**WELWYN HATFIELD BOROUGH COUNCIL
EXECUTIVE DIRECTOR - PLANNING, PUBLIC PROTECTION AND GOVERNANCE**

Application No: 6/2019/2228/LAWP
Location: Just House Coopers Lane Northaw Potters Bar EN6 4NJ
Proposal: Certificate of lawfulness for an outbuilding
Officer: Ms Lucy Hale

Recommendation: Refused

PROPOSED SIDE ELEVATION

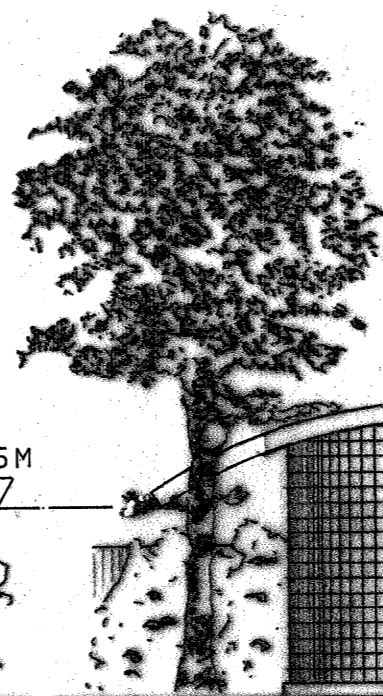
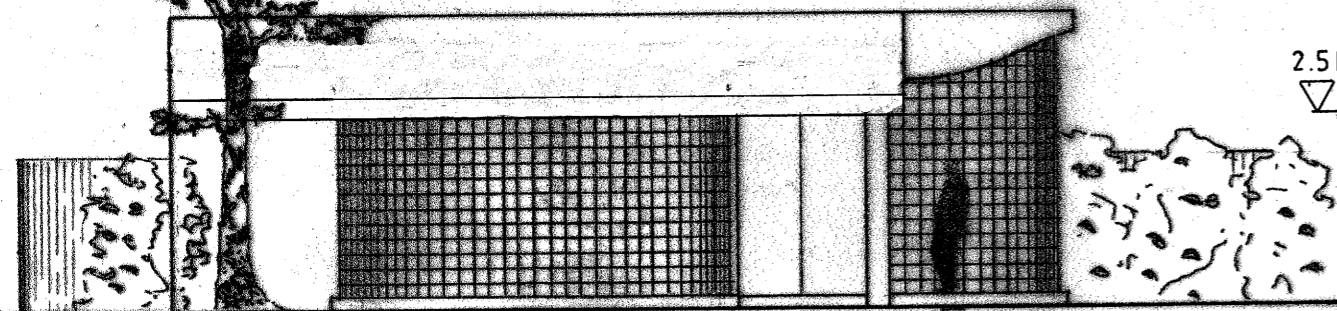
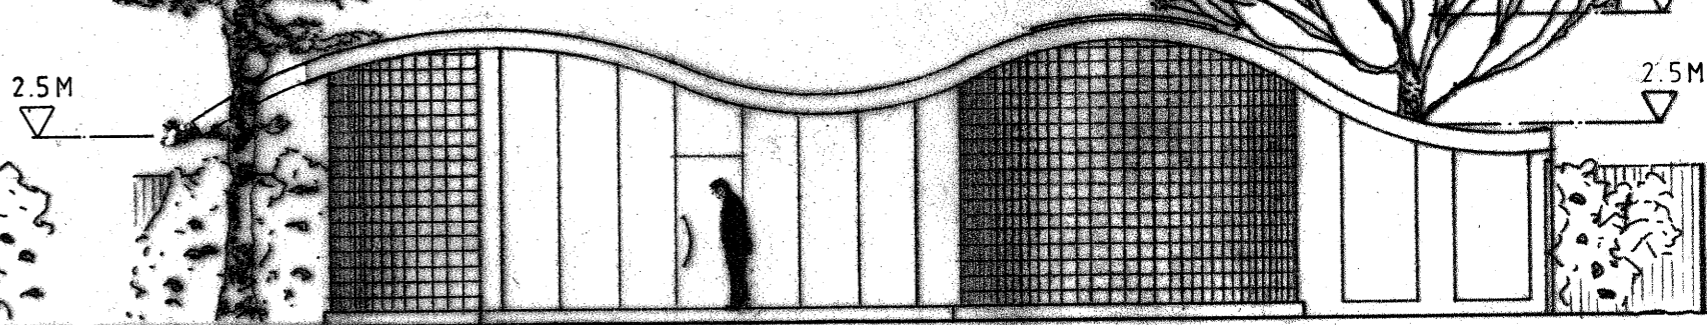
(f) the height of the eaves of the building would exceed 2.5 metres;	Y	N
(g) the building, enclosure, pool or container would be situated within the curtilage of a listed building;	N	N

1. The proposed outbuilding would exceed the limitations of E.1(f) in Schedule 2, Part 1, Class E of the Town and Country Planning General Permitted Development (England) Order 2015 (as amended) by virtue of the height of eaves of the building measuring higher than 2.5 metres.
2. The proposed outbuilding would exceed the limitations of E.1(c) in Schedule 2, Part 1, Class E of the Town and Country Planning General Permitted Development (England) Order 2015 (as amended) by virtue of the outbuilding situated on land forward of a wall forming the principal elevation of the original dwellinghouse.
